Mark E. Jones, PE
Structural Engineering and Design

Ref: Site Observations and Analysis
20 Warner Hill Ct.
Fuquay-Varina, NC
Project No. 23-216

The above referenced site was observed on February 29, 2024 for the following items:

ROOF PLAN
SCALE: 1/4"=1'-0"

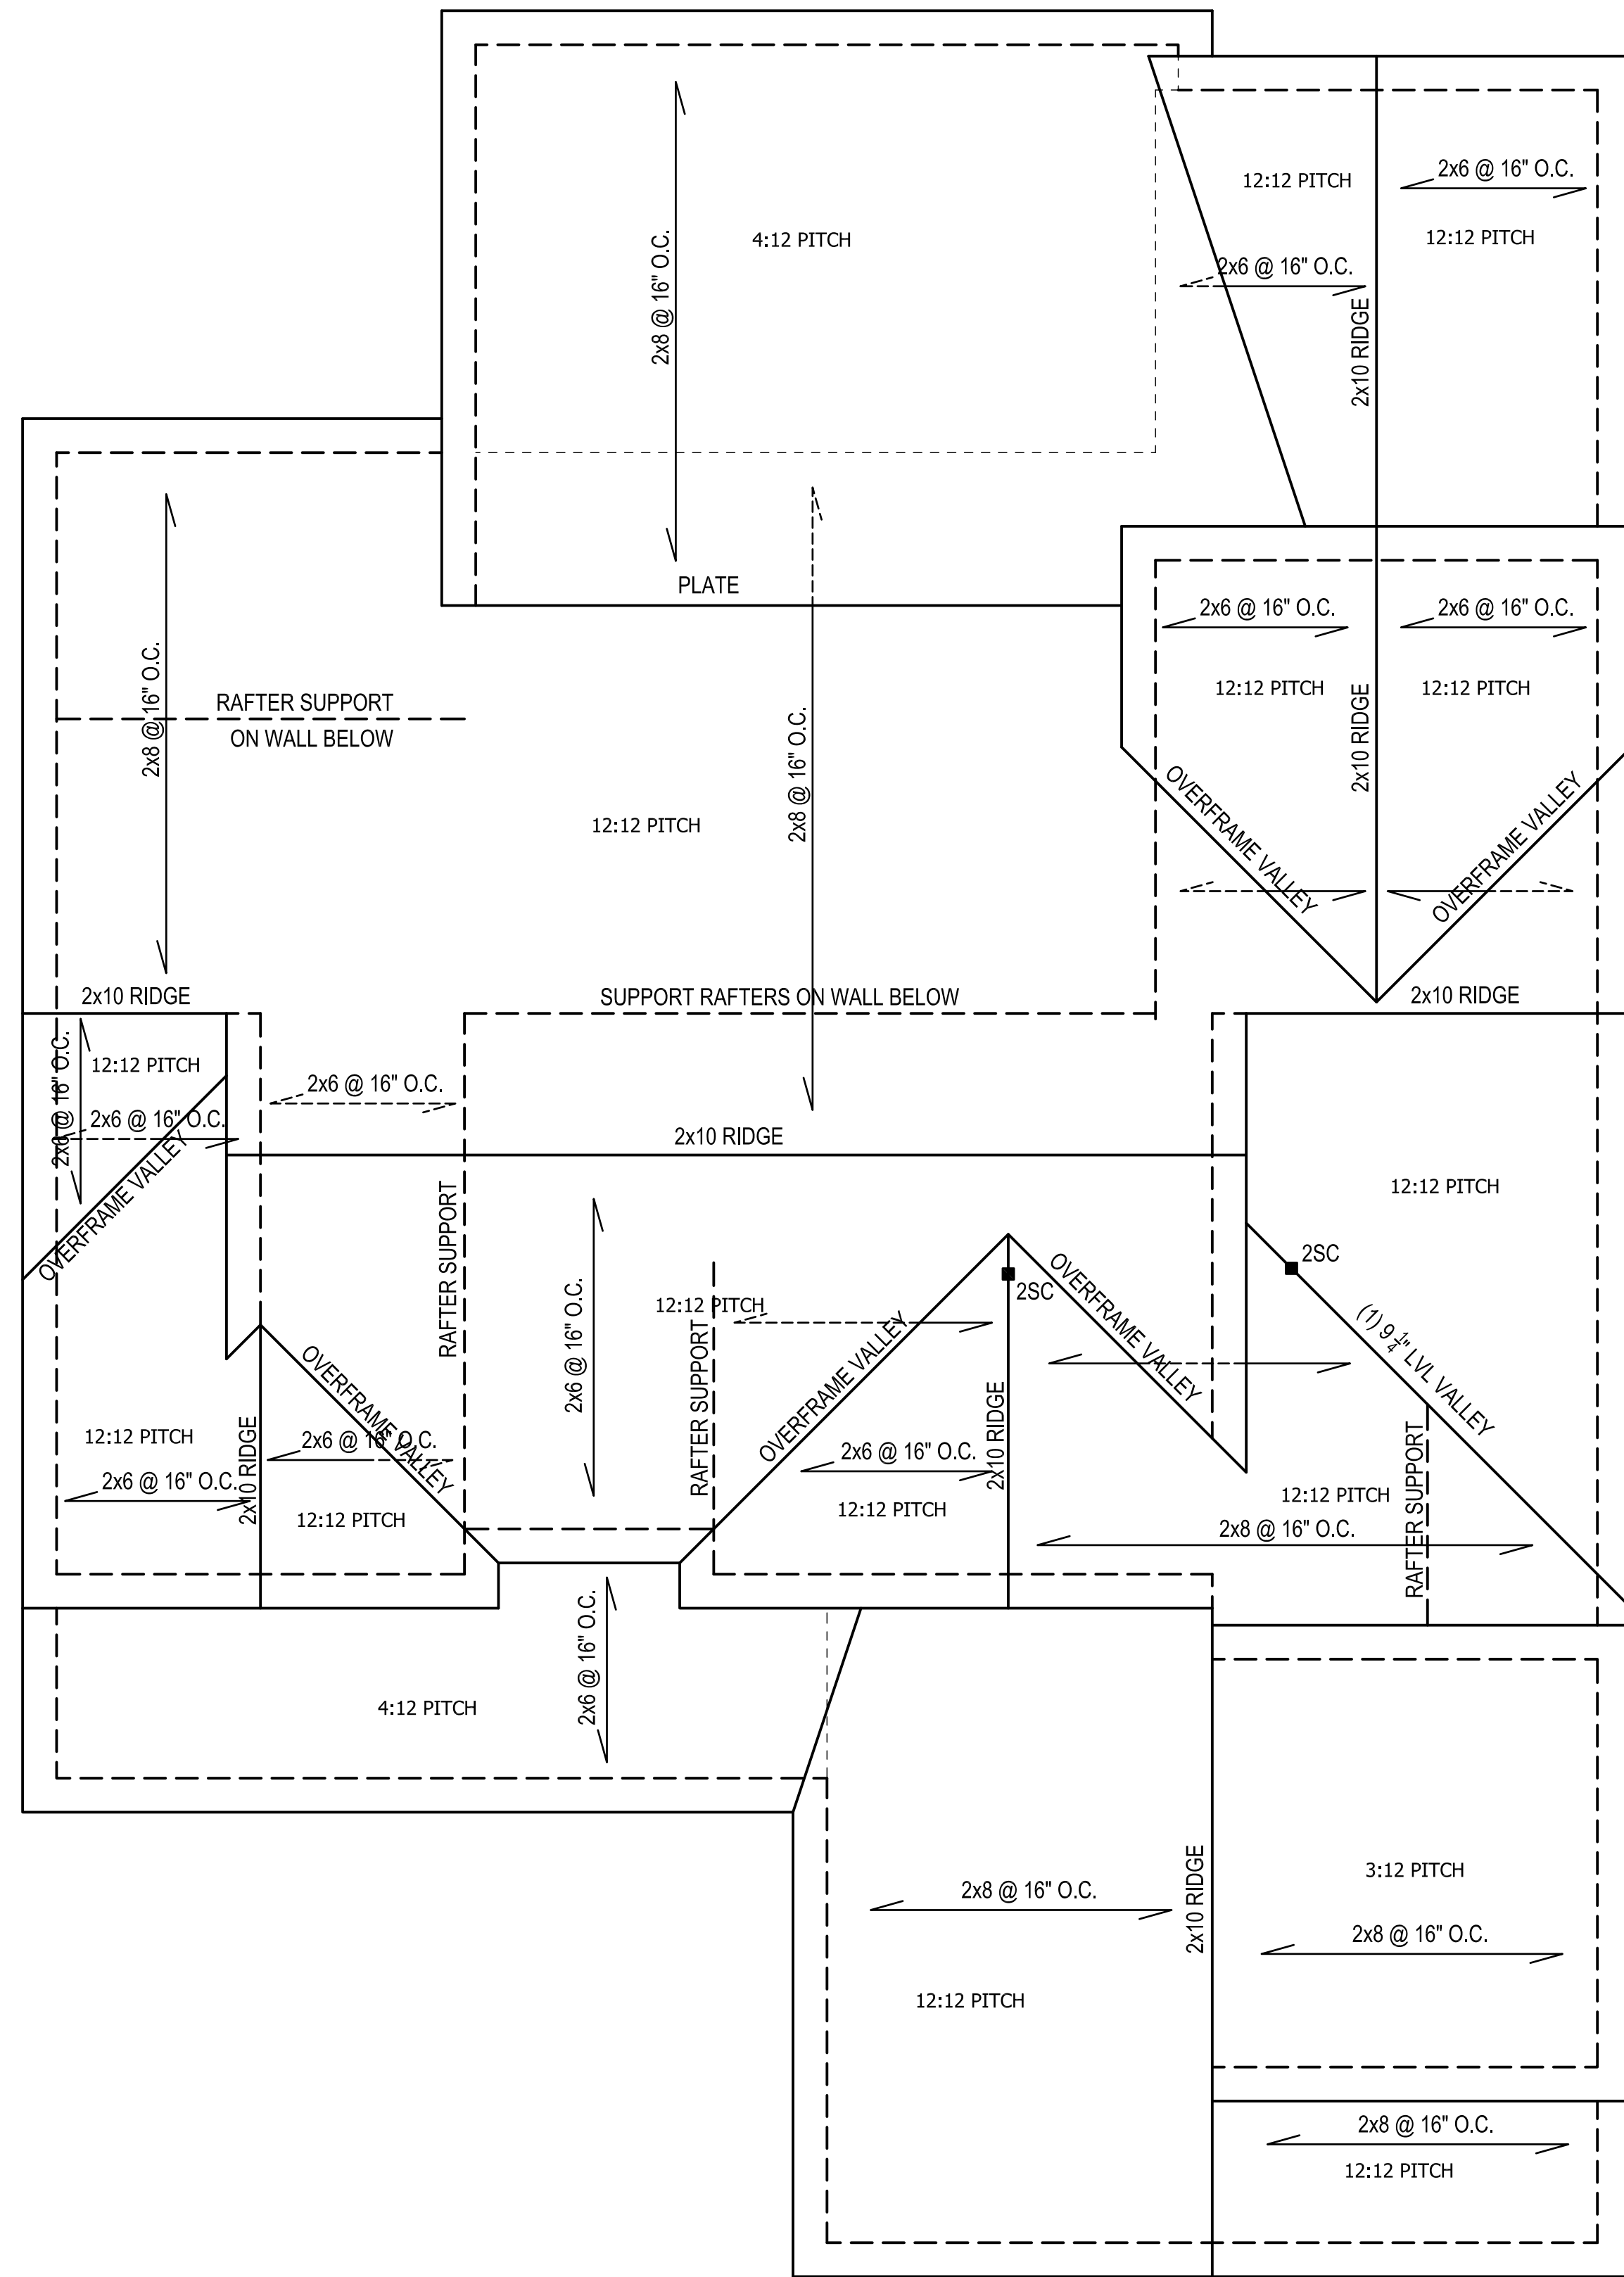
3. Floor truss not bearing on stair wall.
11. Notched stud column in garage over 25 percent.

3. The rear ply of the double I-joist at the stair wall only bears 1 inch on the wall below. The builder shall provide (qty. 3) L30 angles, equally spaced, at the bottom flange of the i-joist and the top plate of the wall.
11. The 4 stud column supporting the front porch header at the garage wall has been notched approximately 1" for a plumbing line. The builder shall provide a 12" strap across the notch at each stud.
